FIRE RISK MANAGEMENT, INC

Memo Report

Subject: Code Review and Life Safety Evaluation; ICW Building Located at 46 Market St., Portland, ME

A-1.2

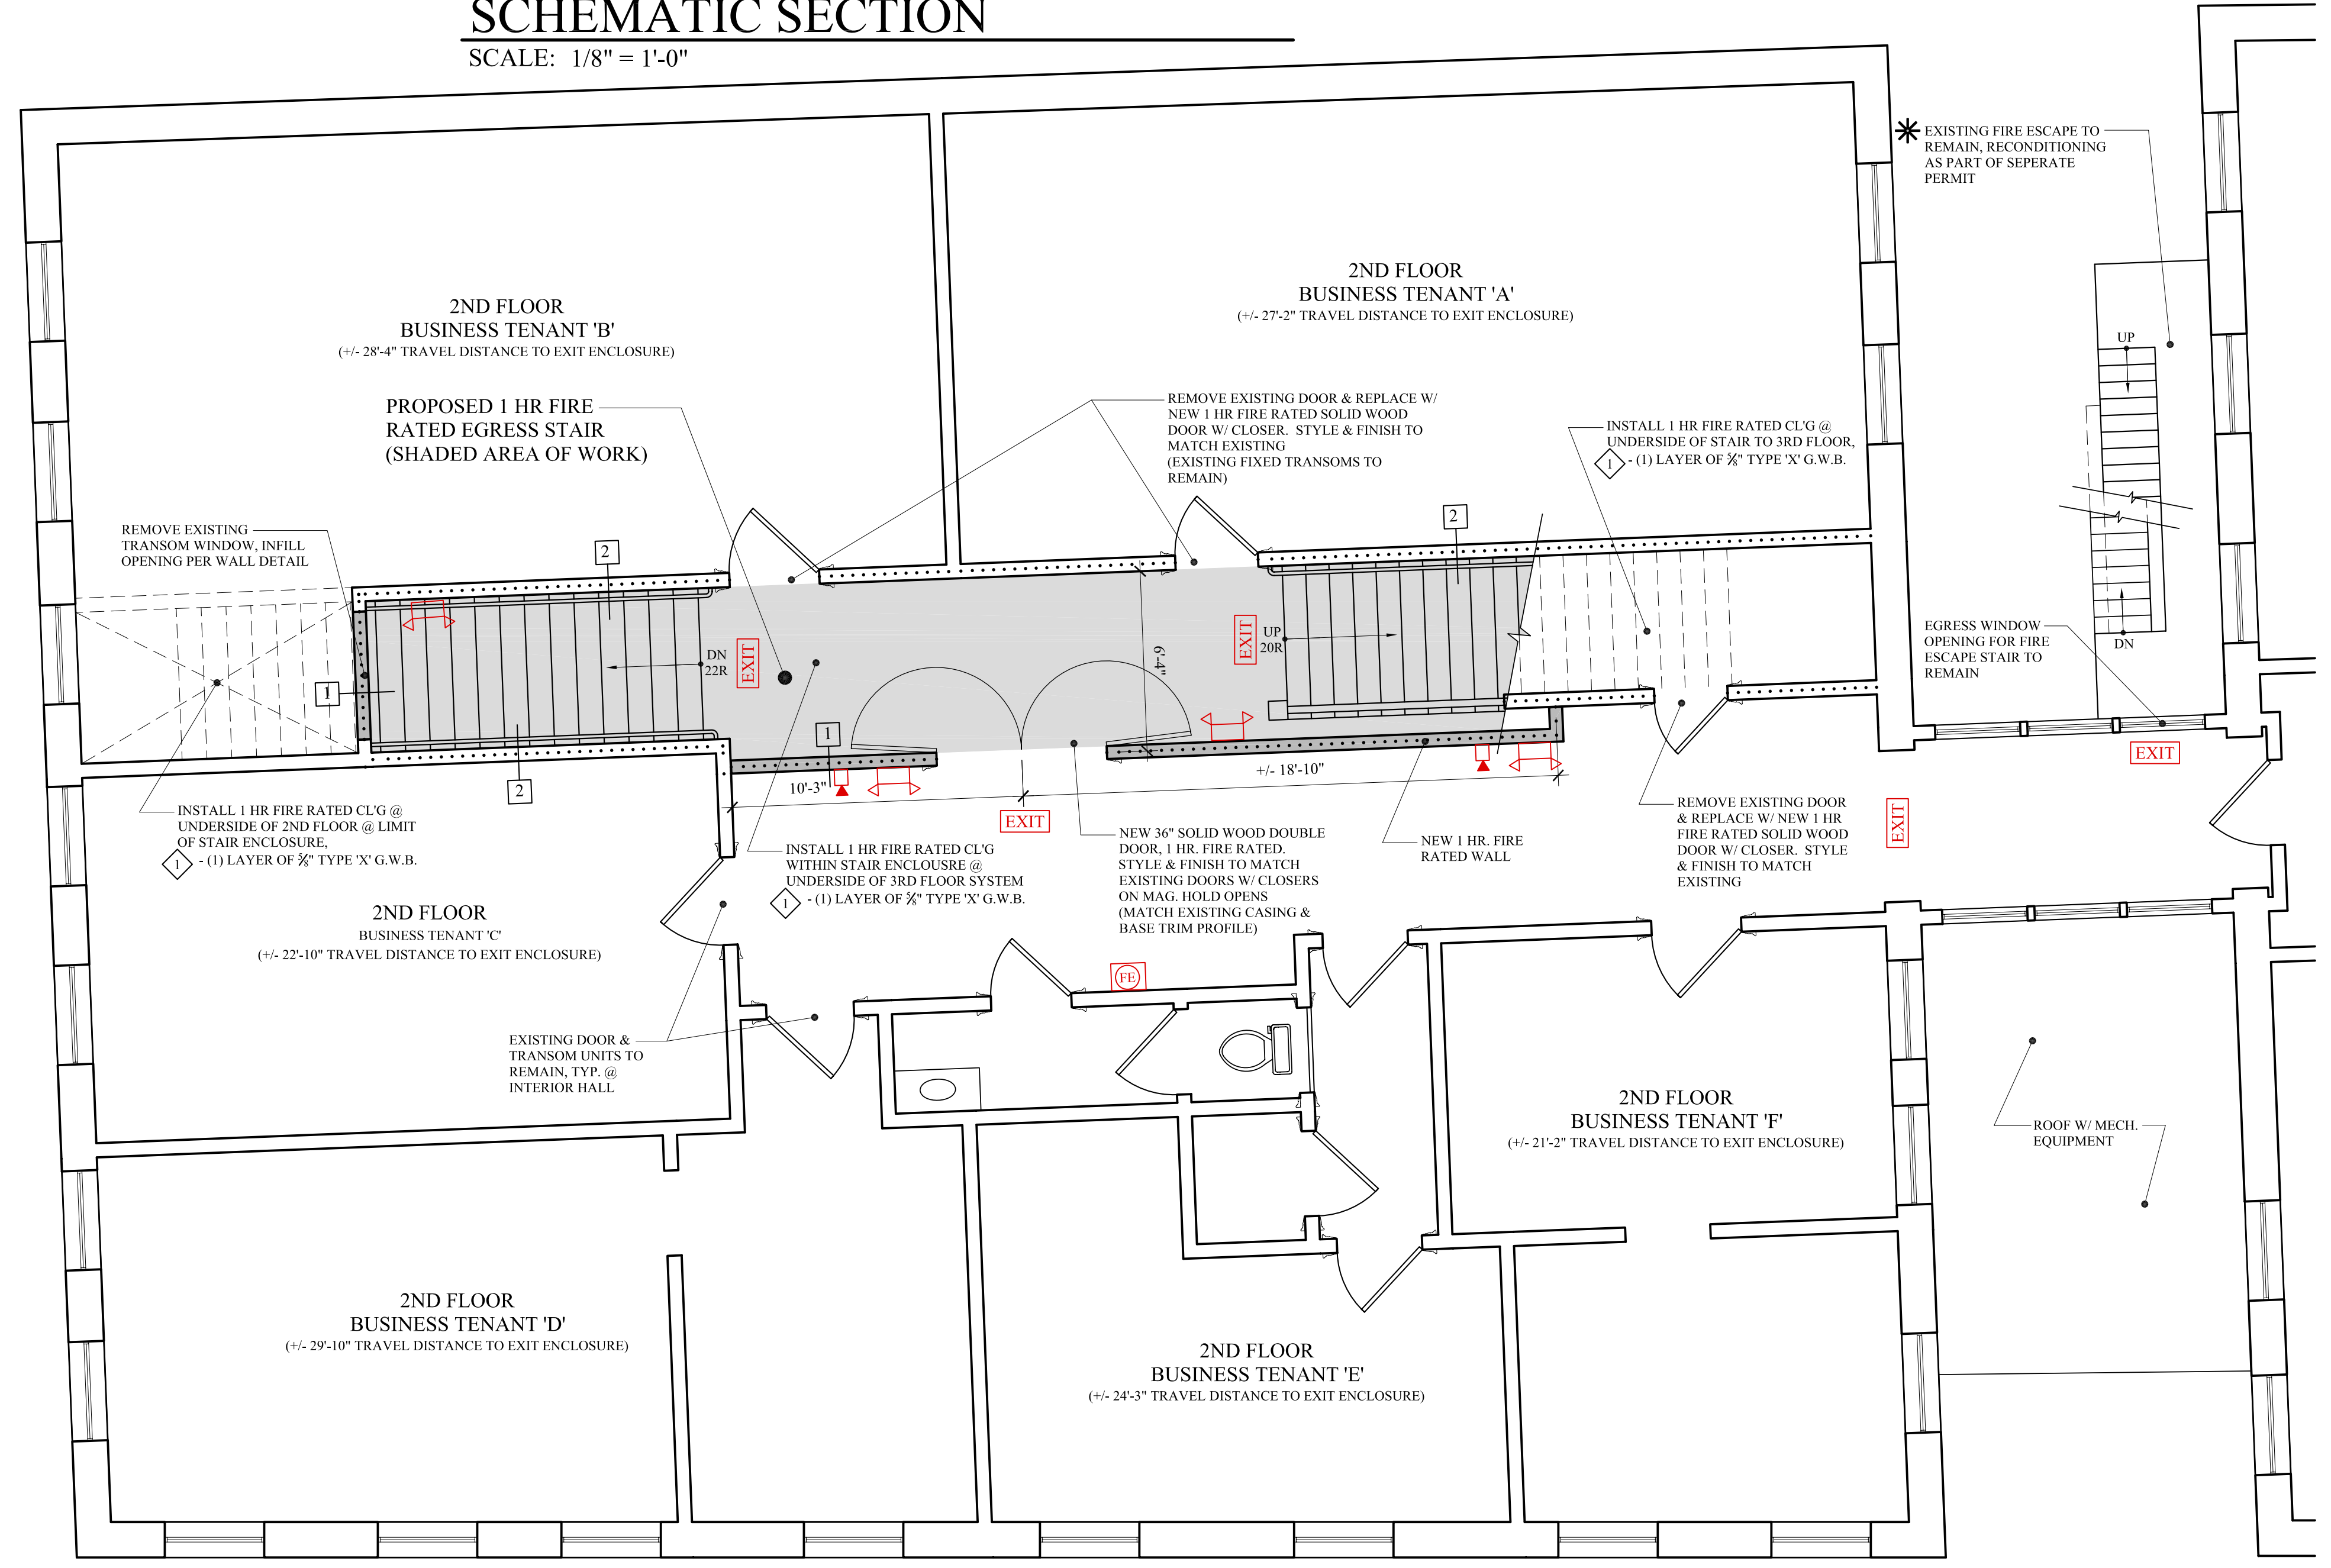
- Add a fire-rated barrier that separates the Exchange St. building from the corridor connecting this building to the Market St. building, including the fire escape stairs mounted on this building that represent the second means of egress. This can be accomplished by the addition of a fire-rated doorway at the Exchange St. end of this corridor. The door assembly and the new wall in which it is installed should have a fire resistance rating of at least one hour. This configuration applies to both the 2nd and 3rd floor levels.

- Any unprotected openings in the exterior walls (windows, etc.) adjacent to, and within 10 feet of, the corridors connecting the two buildings should be modified to provide at least a 1-hour fire resistance rating. Alternatively, the exterior walls of the corridors within 10 feet of an unprotected opening in the buildings' exterior walls can be modified to provide a 1-hour fire resistance rating.

- The 2nd and 3rd floor corridors that access the Market St. apartments, on the Market St. side of the fire-rated door that separates these corridors from the Exchange St. building, should be considered as "exit access" corridors and should be enclosed by barriers that meet a ½ hour fire resistance rating, including the apartment doors leading to the corridor.

- Modify the existing sprinkler system to include the use of quick-response sprinklers throughout. This will further ensure early operation of this system and early notification (via flow switch) of all occupants; thereby allowing additional time for egress.
- Provide new fire escape stairs to replace the existing fire escape stairs on the Market St. building that are in very poor condition and do not provide access to the ground level. Access to the fire escape stairs should be from new doorways installed in each of the 2nd and 3rd floor corridors that connect the two buildings.
